CITY OF ALBUQUERQUE

**Re: 16 Unit Apartments for Ahmet Tiryaki, 2801 12th St. NW,
Request for Permanent C.O. - Approved
Engineer's Stamp dated: 1-13-09 (H-13/D051)
Certification dated: 06-25-10**

**Re: 16 Unit Apartment for Ahmet Tiryaki,
Drainage Report & Grading and Drainage Plan
2801 12th NW
Engineer's Stamp dated 12/24/08 (H-13/D051)**

**Re: 16 Unit Apartment for Ahmet Tiryaki,
Drainage Report & Grading and Drainage Plan
2801 12th NW
Engineer's Stamp dated ¹⁻¹³⁻⁰⁹ ~~12/24/08~~ (H-13/D051)**

16 UNIT APARTMENTS FOR AHMET TIRYAKI
GRADING AND DRAINAGE PLAN

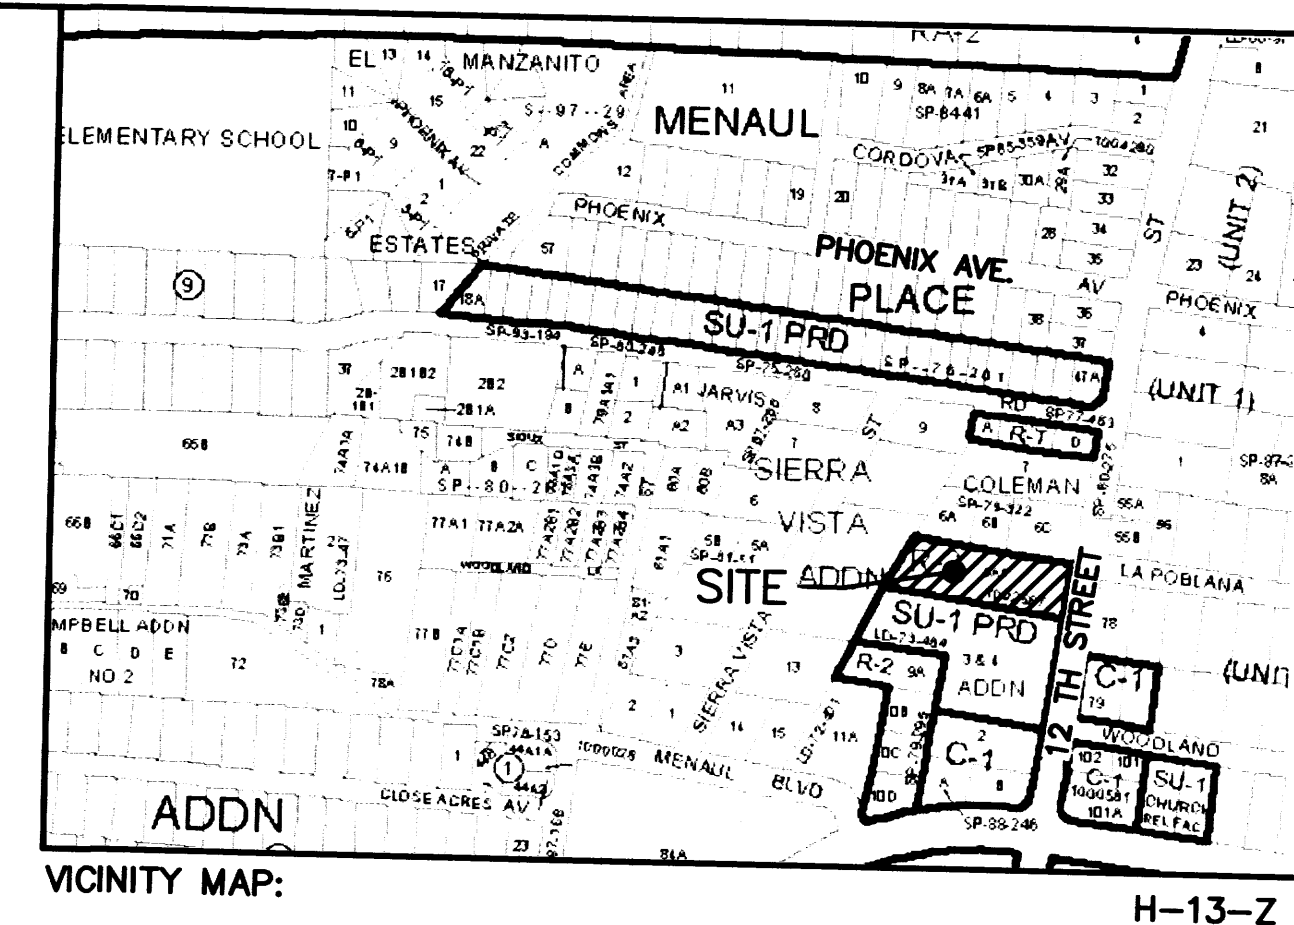
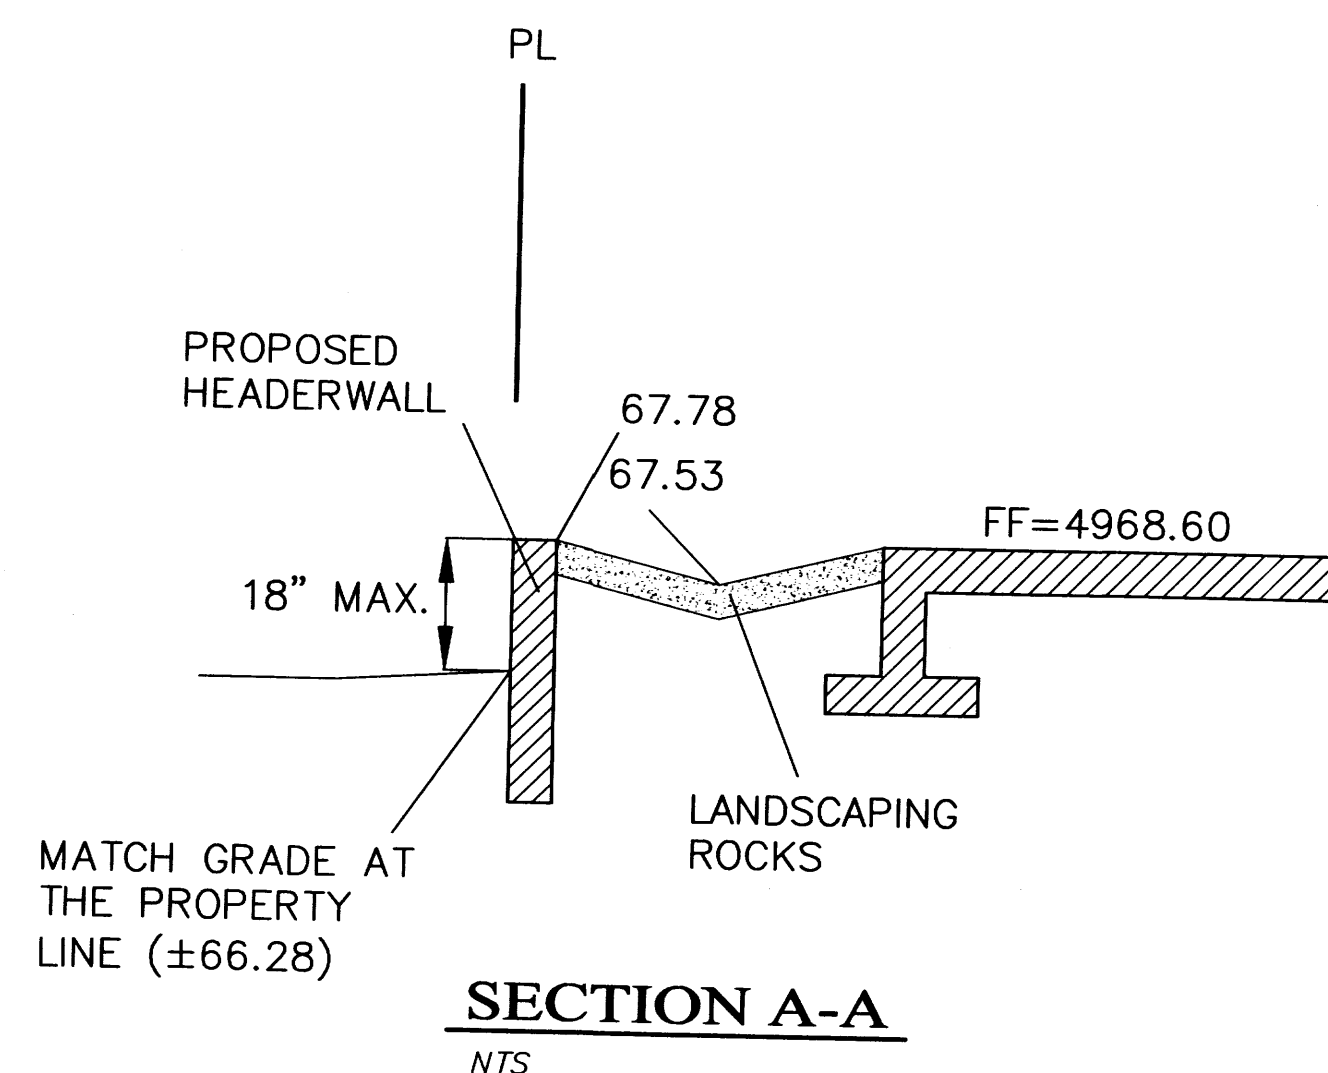
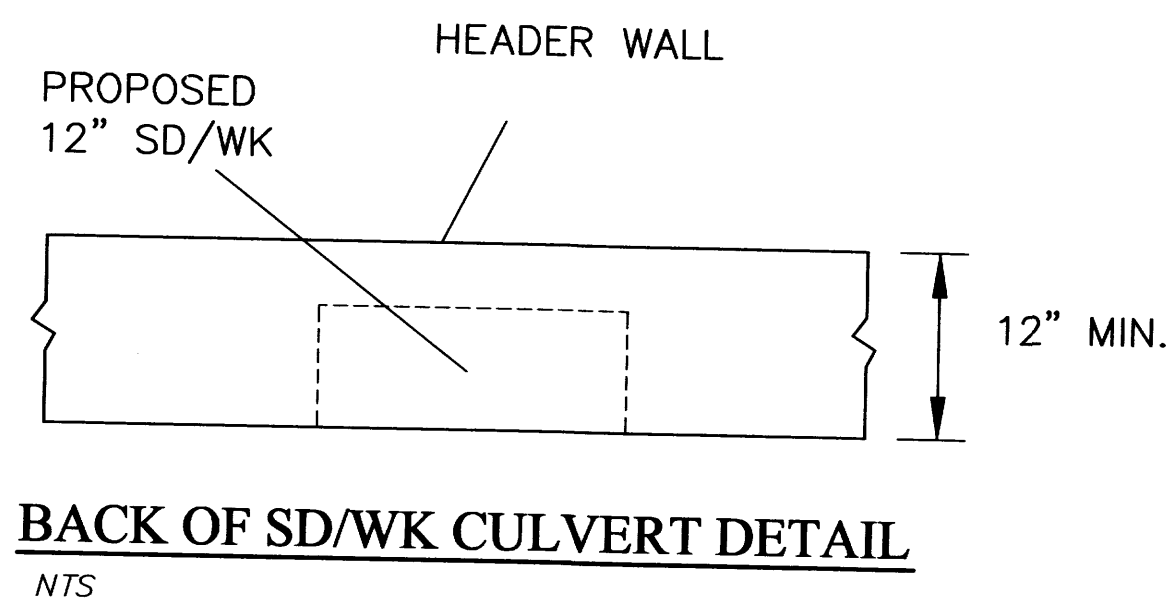
- ✓ • Section A-A of the Grading and Drainage Plan: You show a difference of 30.25 feet from the top of header wall to flow line and a difference of 29.18 from header wall to FF elevation. Please check and verify these elevations points.
- Drainage Report: You are requesting a re-plat approval of the existing lot. The request is denied because this will require a DRB action and not a Drainage submittal approval. Please correct this statement on the report and I refer to DRB for this type of request.
